Agenda Item: Construction Traffic and Access

From [REDACTED], Gt Staughton Parish Council [REDACTED]

Figure 2-4 Proposed Site Access (Rev P01)

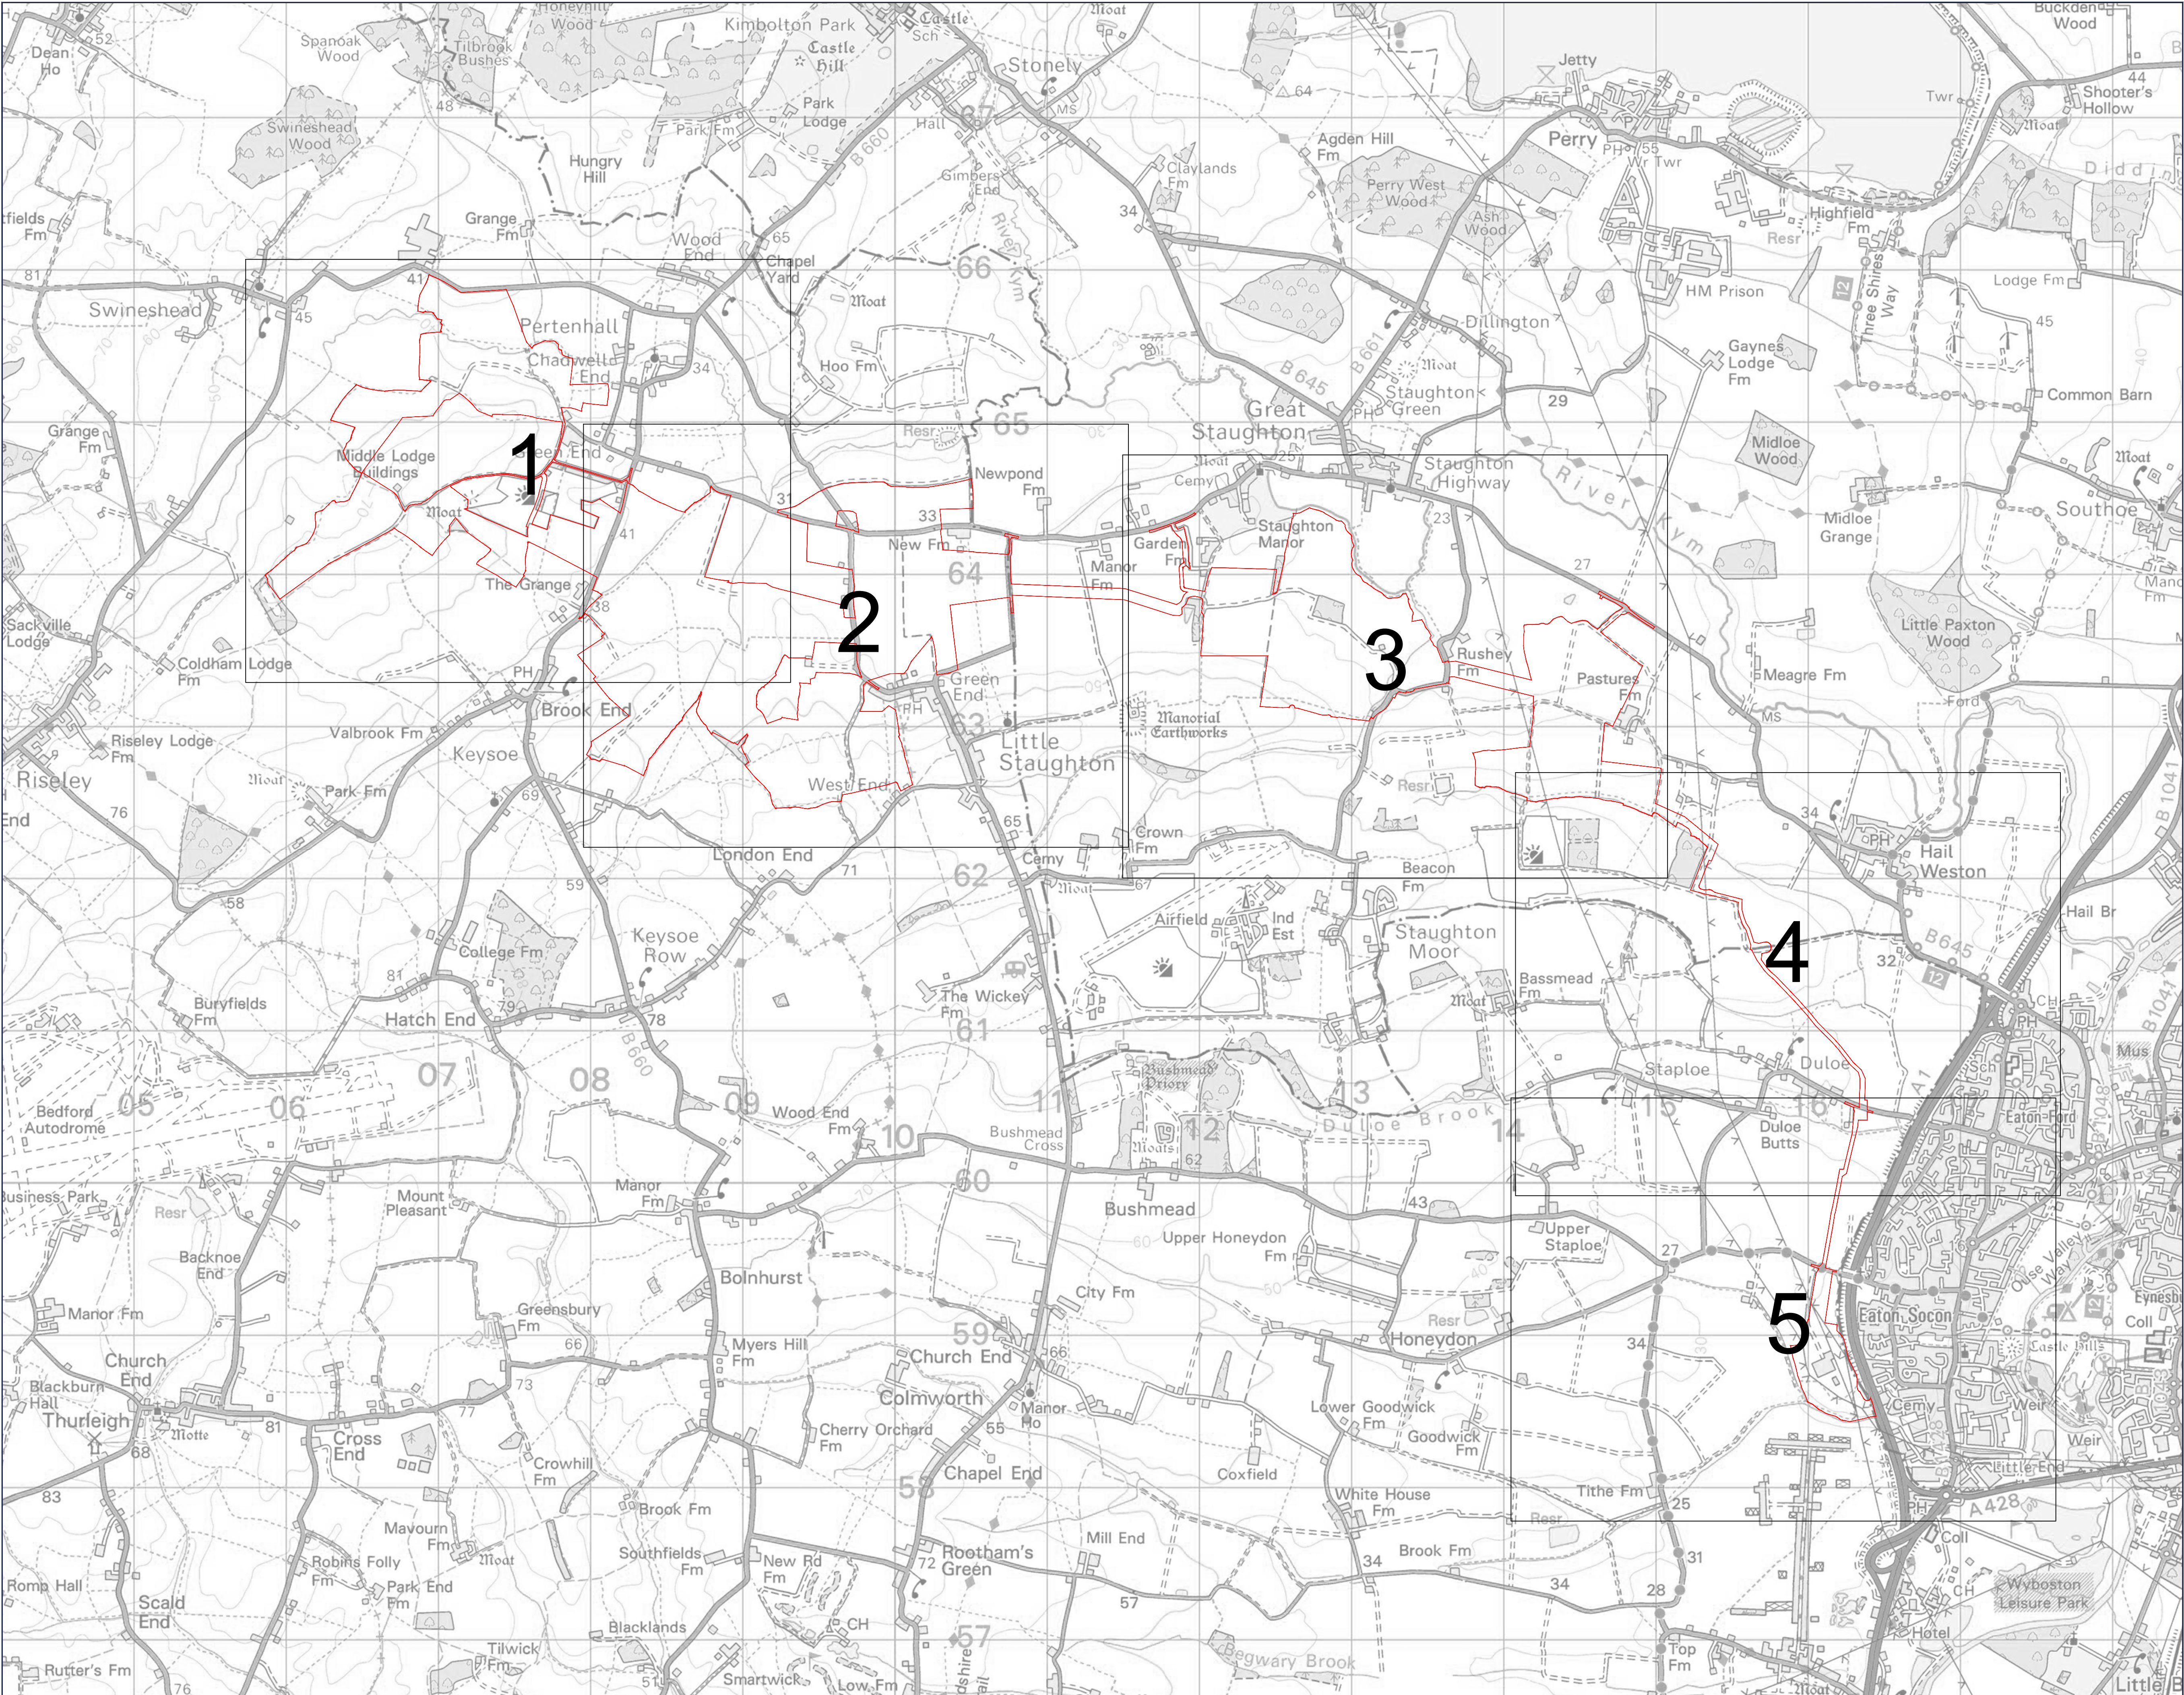
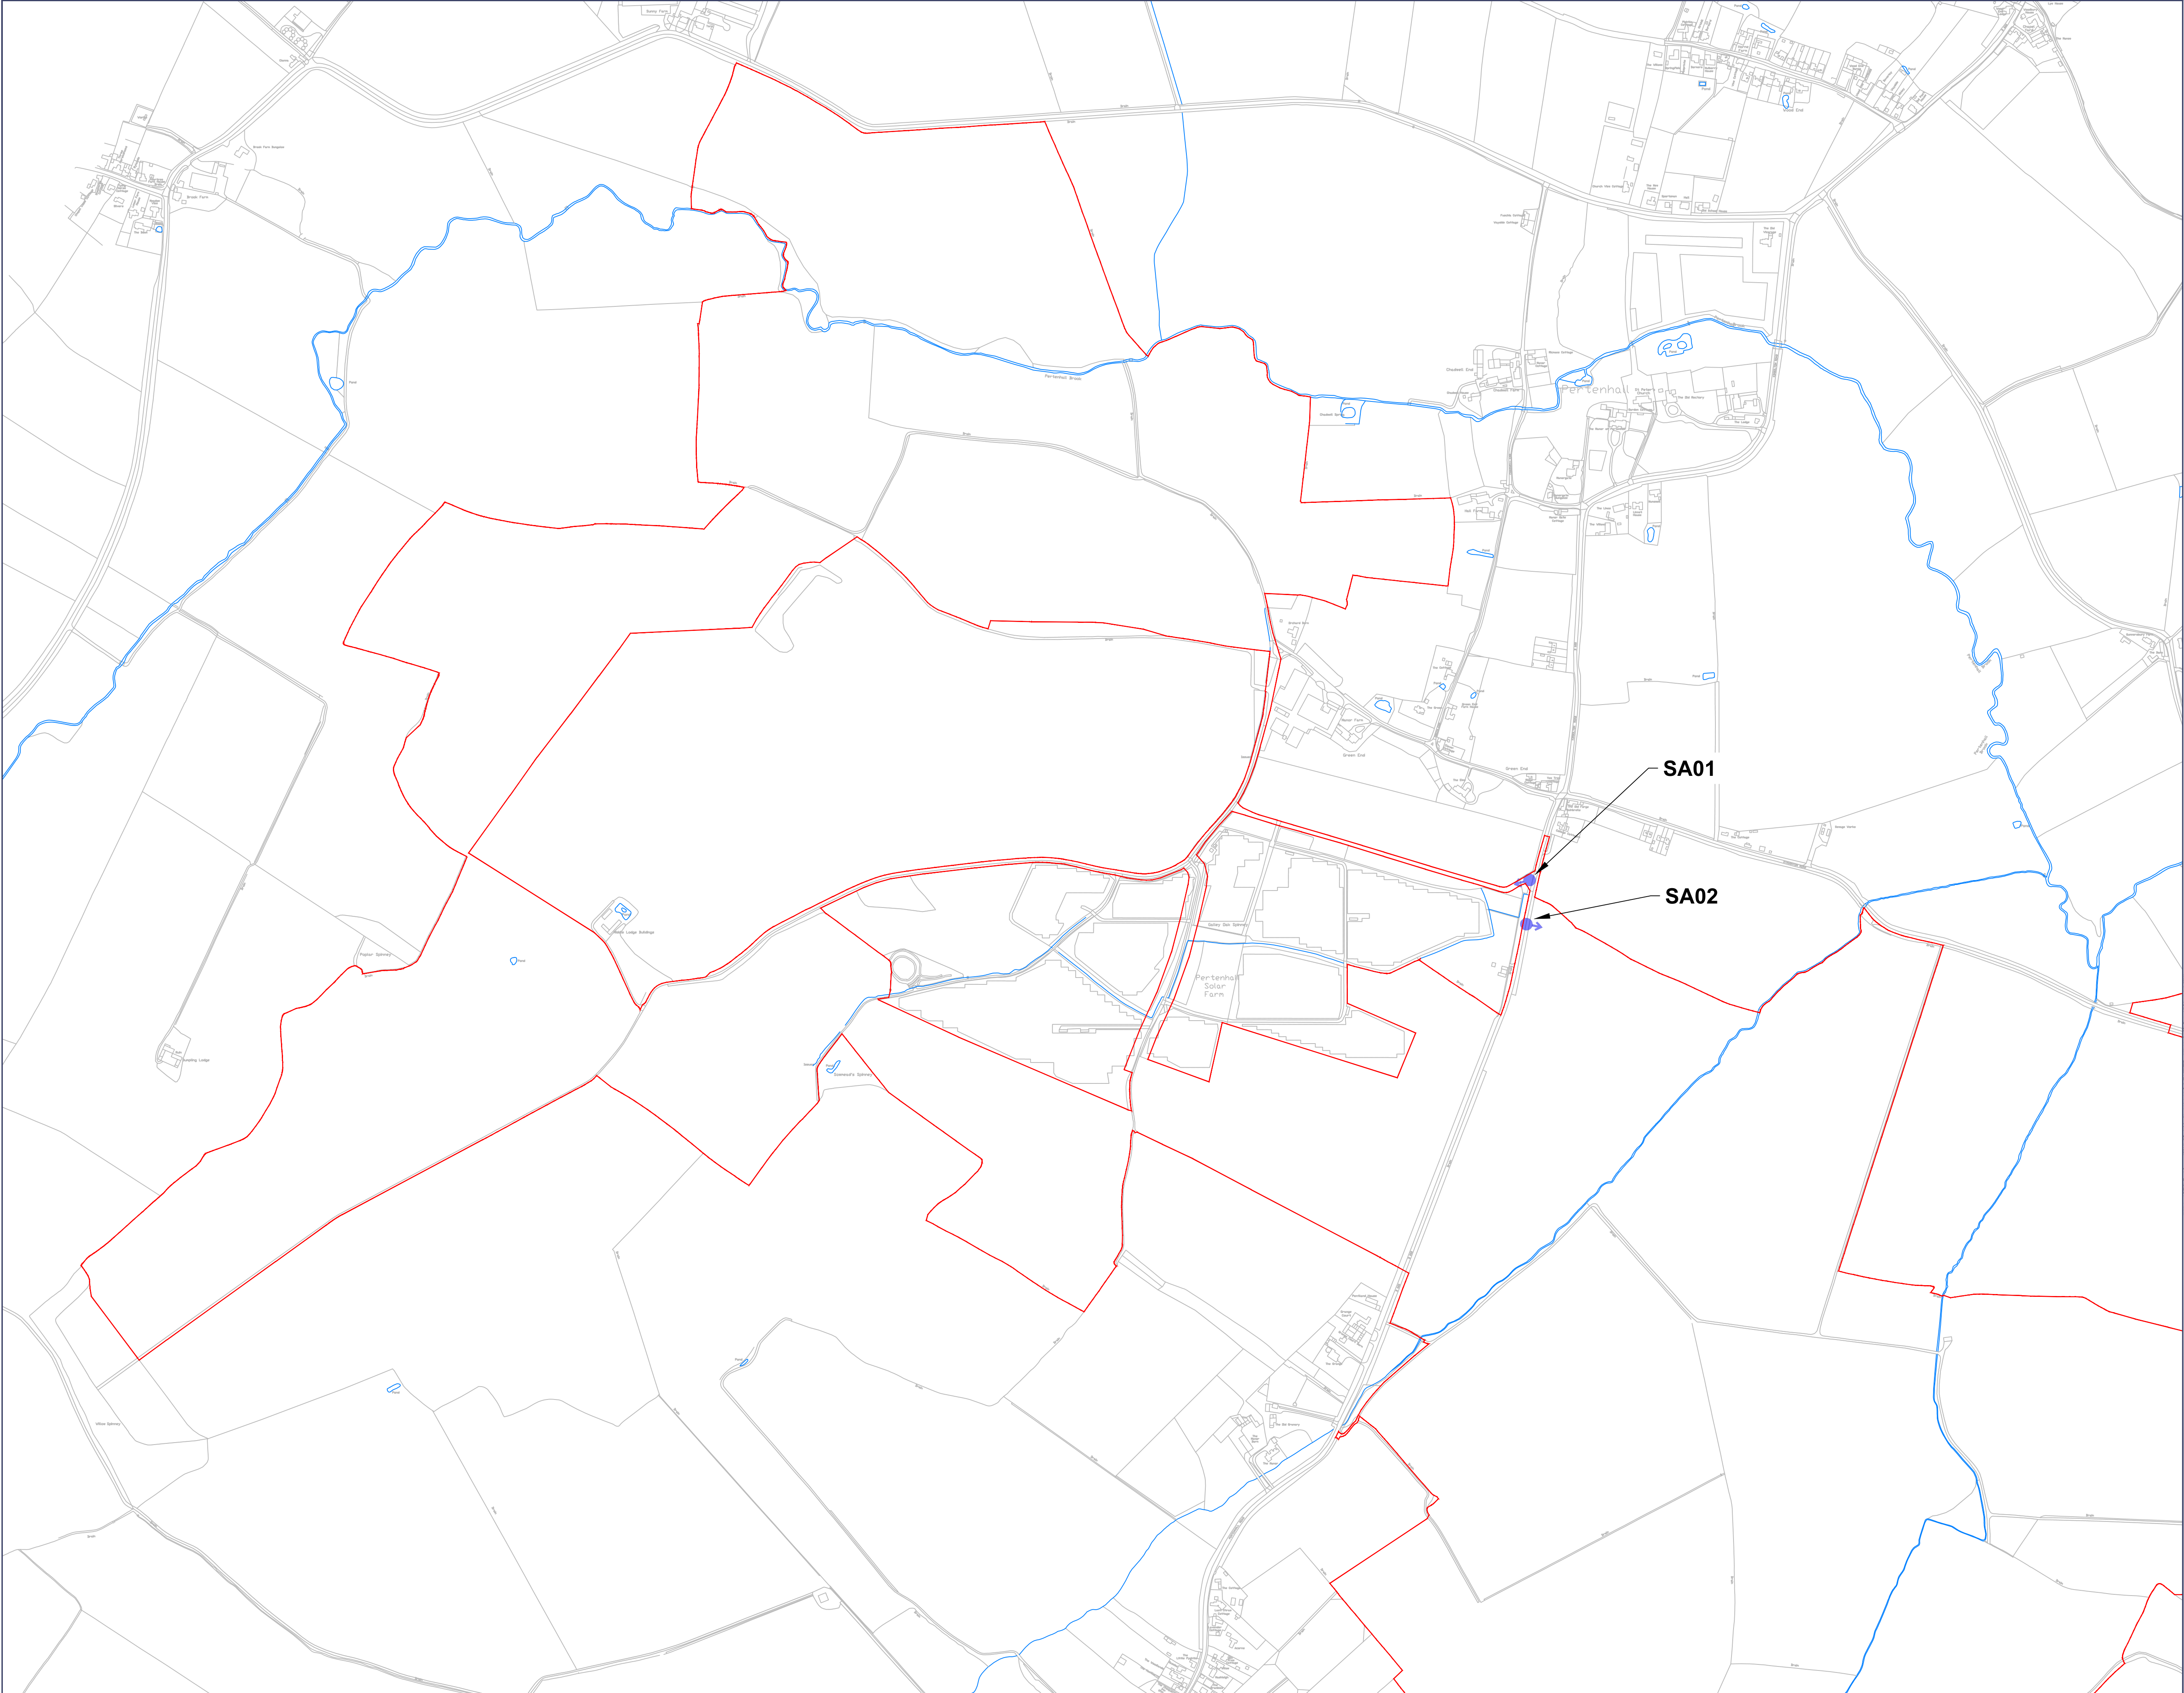
We understand that Brockwell's intention is for all the site traffic to come from the A1 along the B645 and enter the point at SA16. However, we would like to see a commitment that this will be strictly enforced otherwise we suspect that construction traffic including HGVs will be tempted to take the shortcut from SA12 back through the village in a way that would be exceedingly dangerous and disruptive:

B645 (MAIN ACCESS SA16 to site D). This stretch of road is considered locally to be extremely dangerous:

We are concerned that the project will cause obstruction on the B645 (especially around the main site D access SA16) which is the route to and from work school and shops for many parish residents. Any blockages, hold-ups or temporary traffic signals will come at a significant economic and social cost to local residents.
